Albion Park Rail Bypass

Illawarra BUG feedback on the Albion Park Rail Bypass Environmental Impact statement

# Map 3 - Southern Interchange

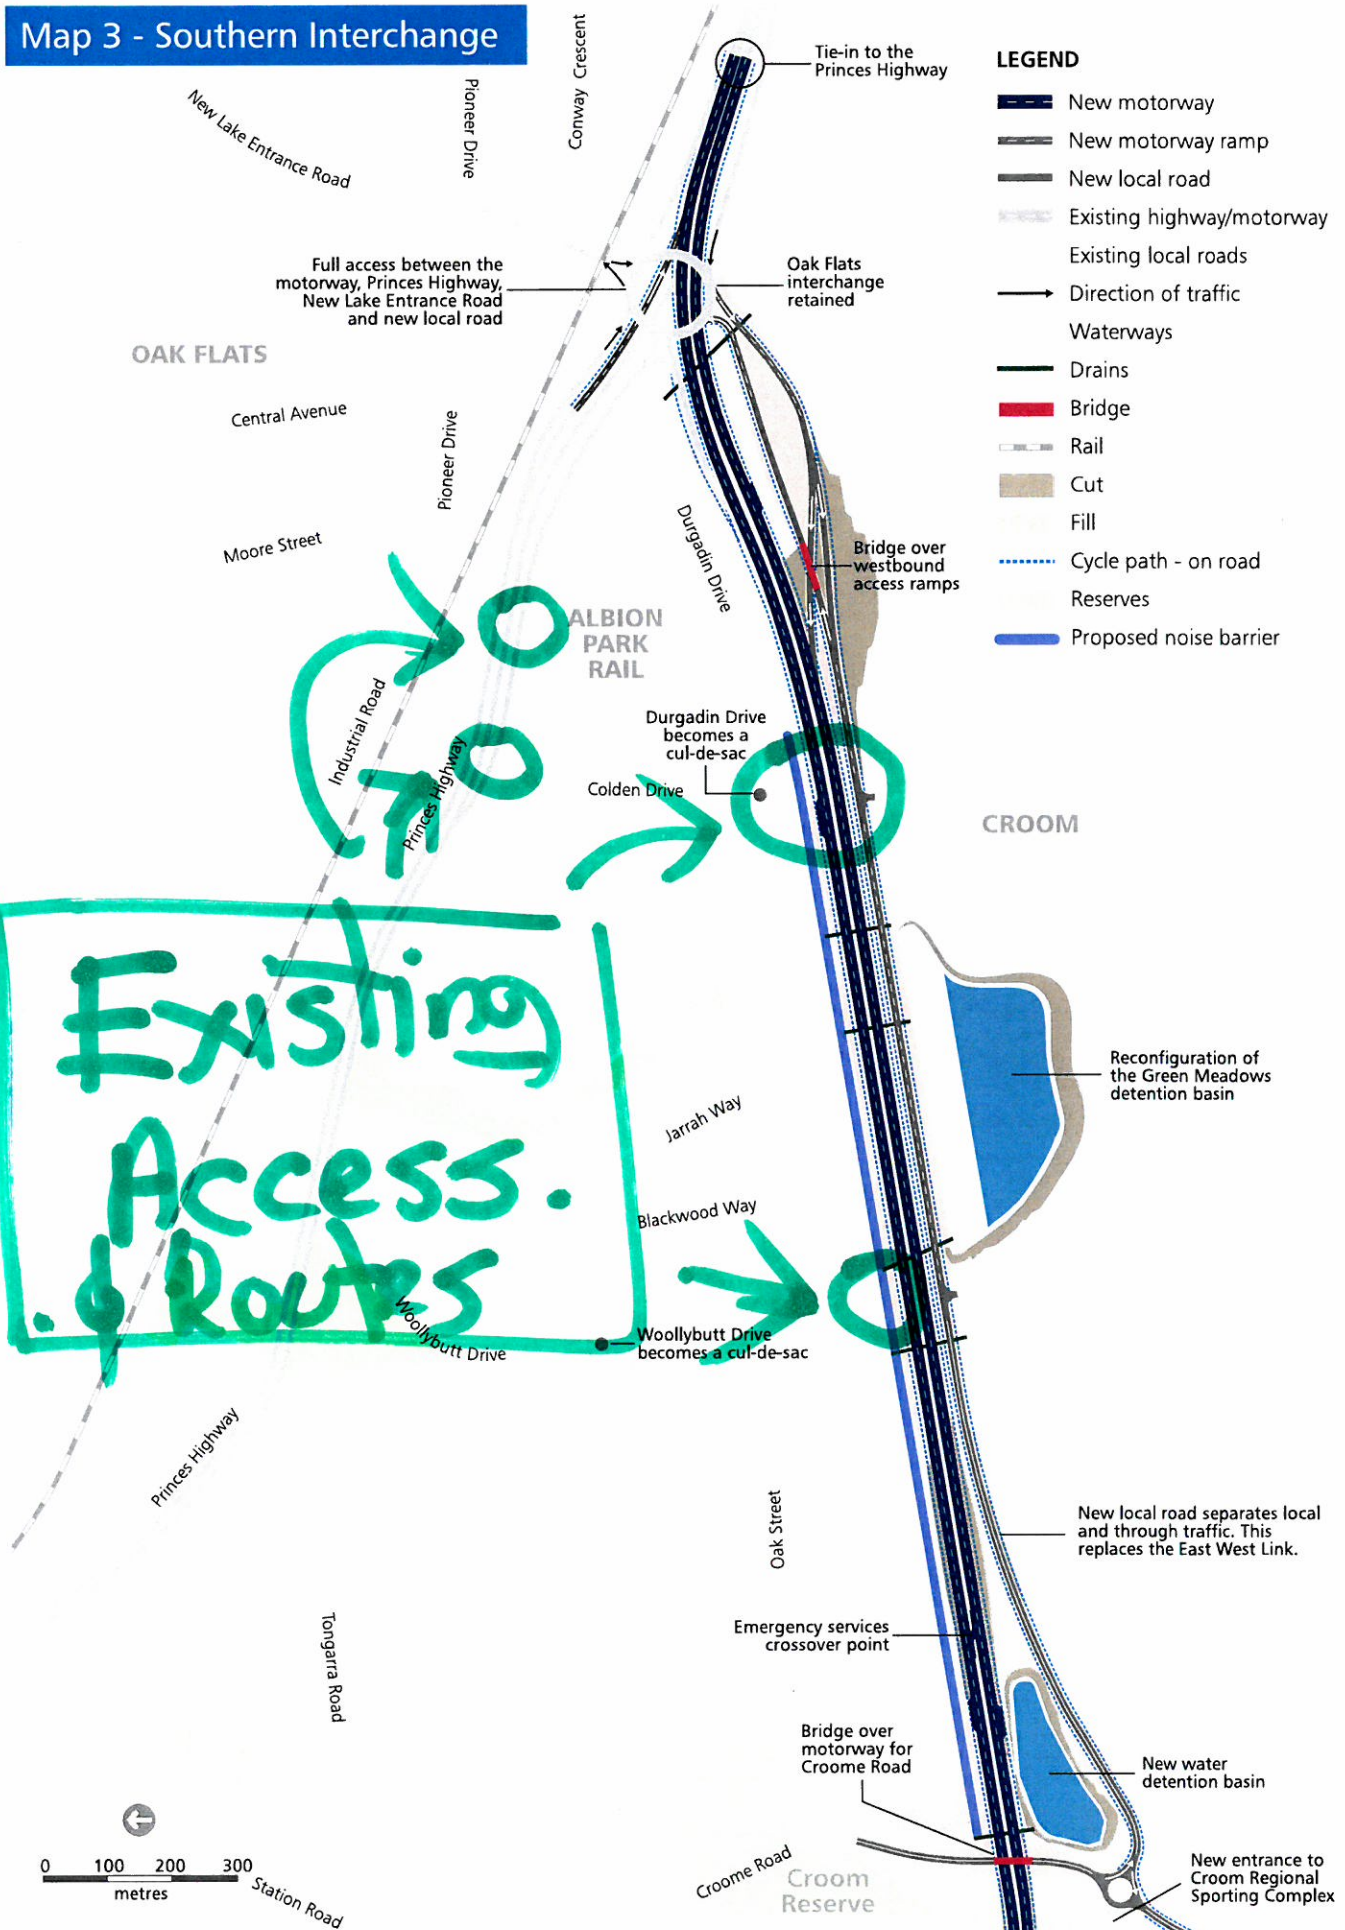
However, we share their concern that a separated cycleway has not been included between Croom Road and Durgadin Drive. This is especially concerning as it involve a **reduction** in cycling amenity and safety as the existing link from the East West Link Road will be severed by the new bypass.

The suggested solution from iBUG (in their attached submission) should be included in the project as a matter of priority so as to achieve the NSW Government's aims set out above. This separated shared path along the north side of the sound barrier is a sensible addition which will promote Active Transport and local community connections.

Our only outstanding concern is the lack of a separated bicycle route or shared path between Croom Road and Durgadin Drive as the existing link from the East West Link Road will be severed by the new Bypass, forcing cyclists to use the hazardous New Lake Entrance Road interchange.

Our proposal to provide a bicycle shared path along the north side of the sound barrier as seen on the marked-up map 3 would provide a safe route to encourage more people to cycle, without using the motorway. This route would add a substantial link as it would provide a safe route between the existing cycling infrastructure in Croom Reserve and Oak Flats when linked with back streets, the signalised intersection on the Princes Highway and the pedestrian rail crossing.
